PLAN-024569

Proposal: Replacement detached garage.

Site: 9 Ancton Close, Ancton, Middleton-On-Sea, PO22 6ND.

M/109/18/HH

PROPOSED GROUND FLOOR PLAN

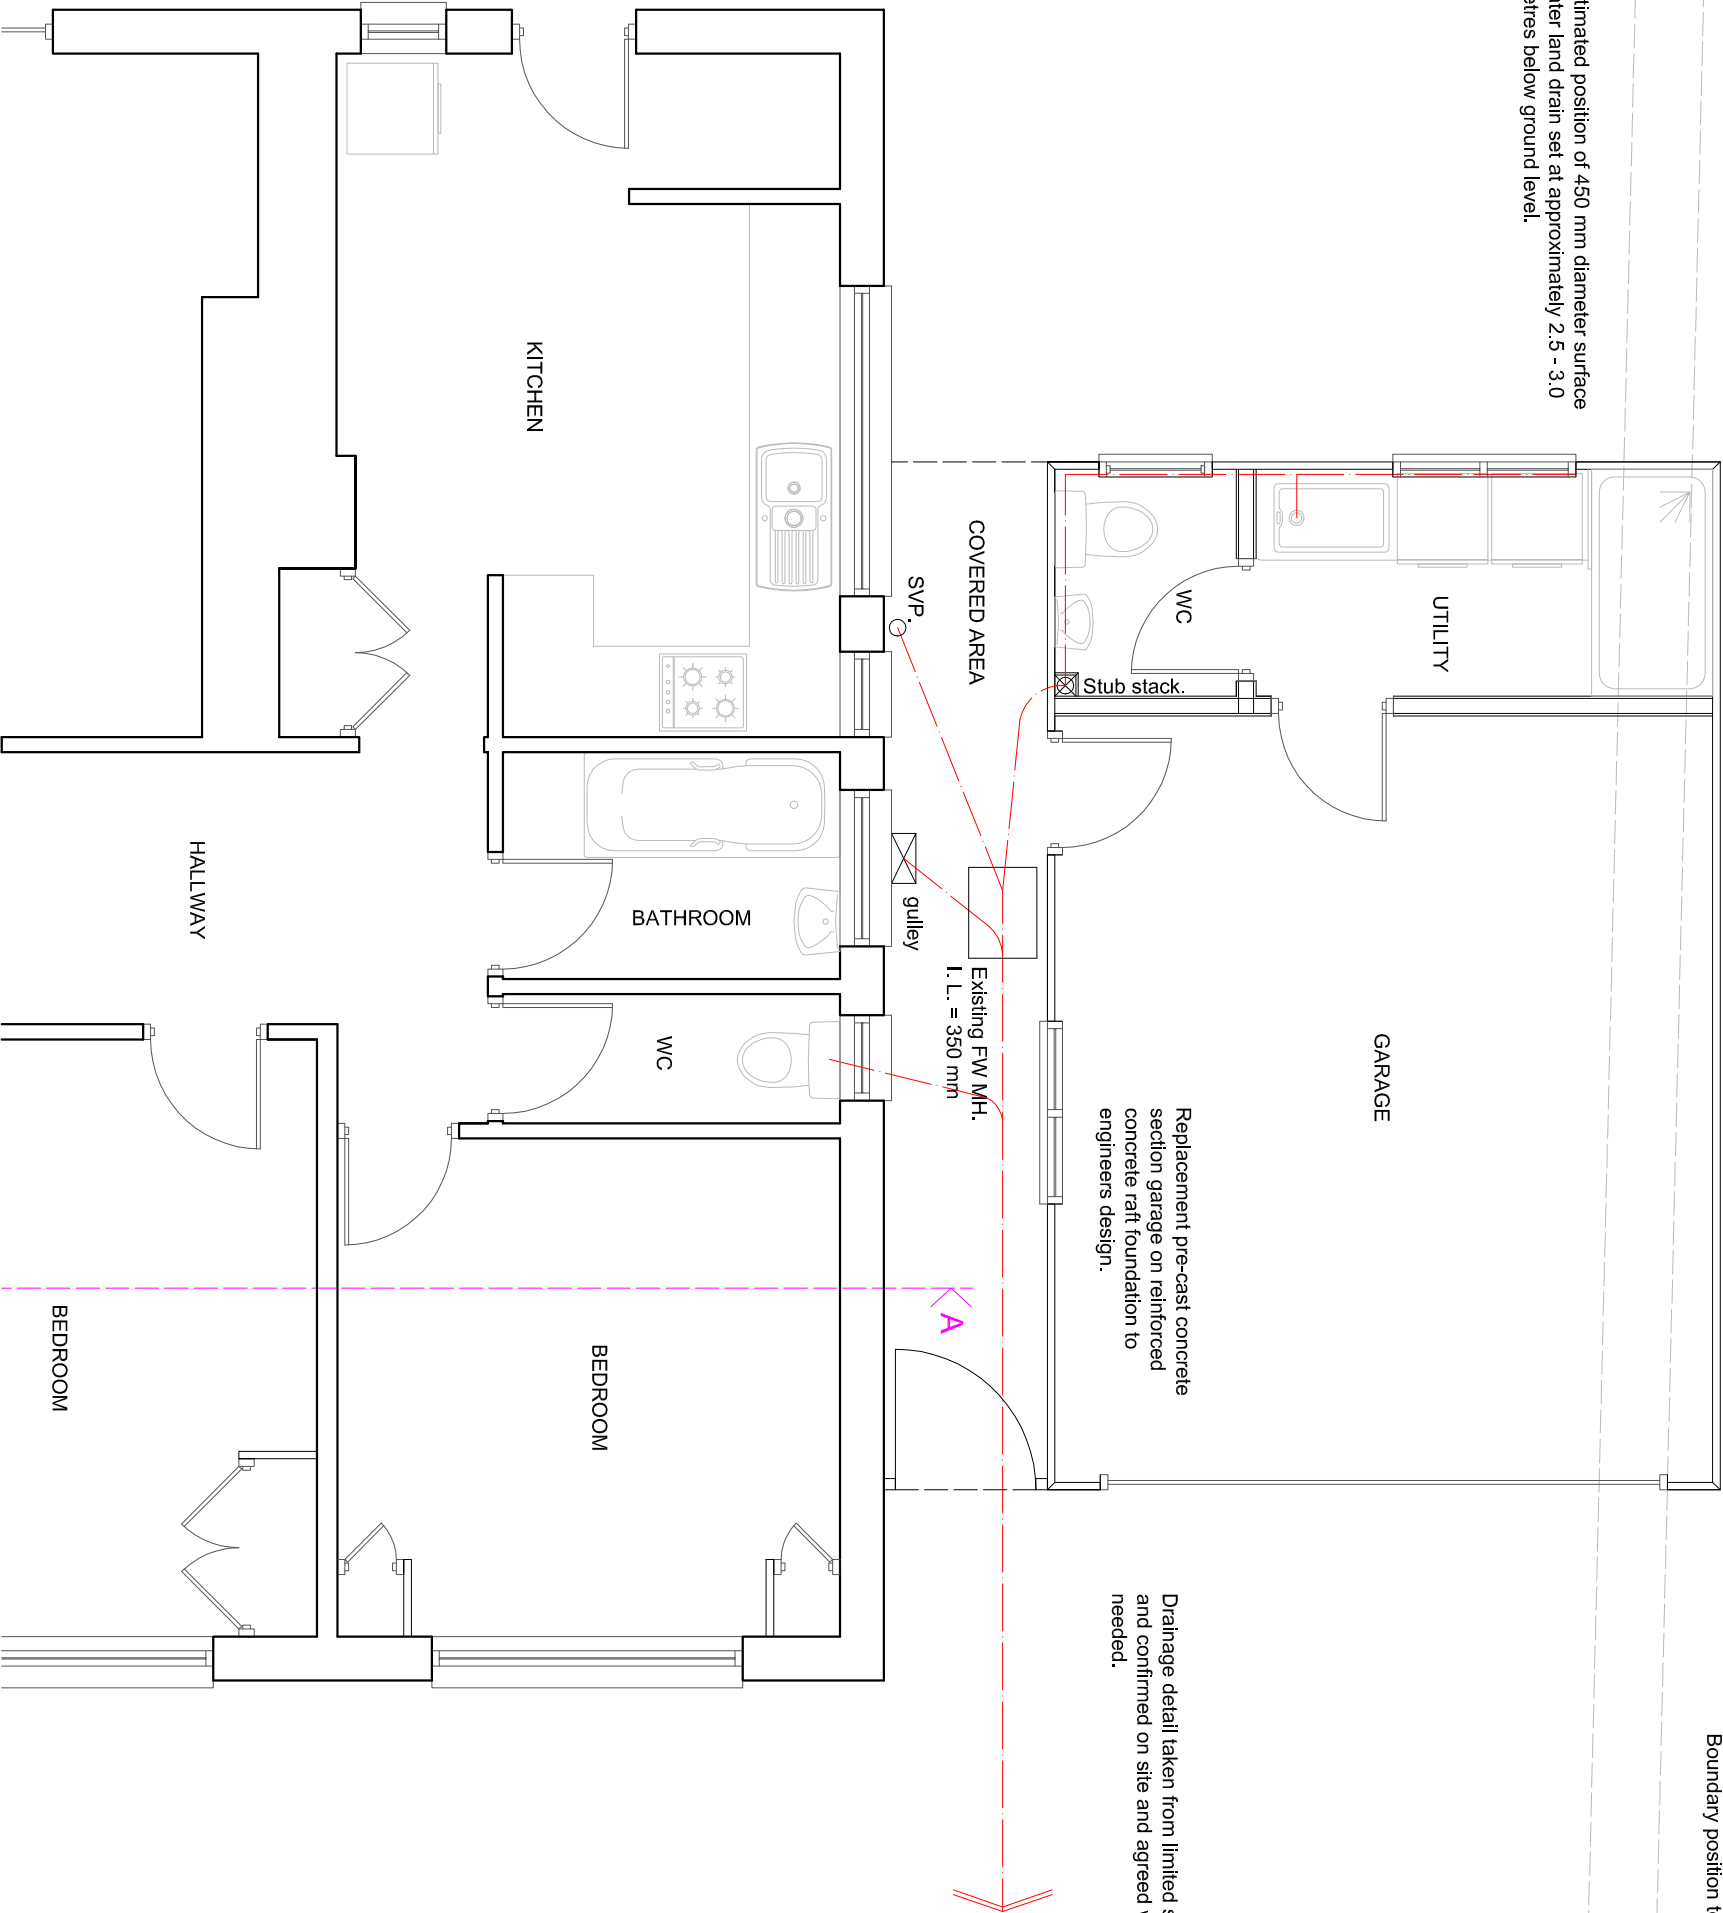
Please note that the site plan shows sewer crossing the site which is not shown on our records. It appears that the developer is intending to build over to a sewer. Building over a "public sewer" is not normally permitted by Southern Water. An investigation of the sewer is required to ascertain its condition, the number of properties served, and potential means of access, before any decision can be made as to whether it would be acceptable for the proposed development close to the sewer. Part H of the Building Regulations dictates that the matter is determined by the sewerage undertaker – in this case Southern Water.
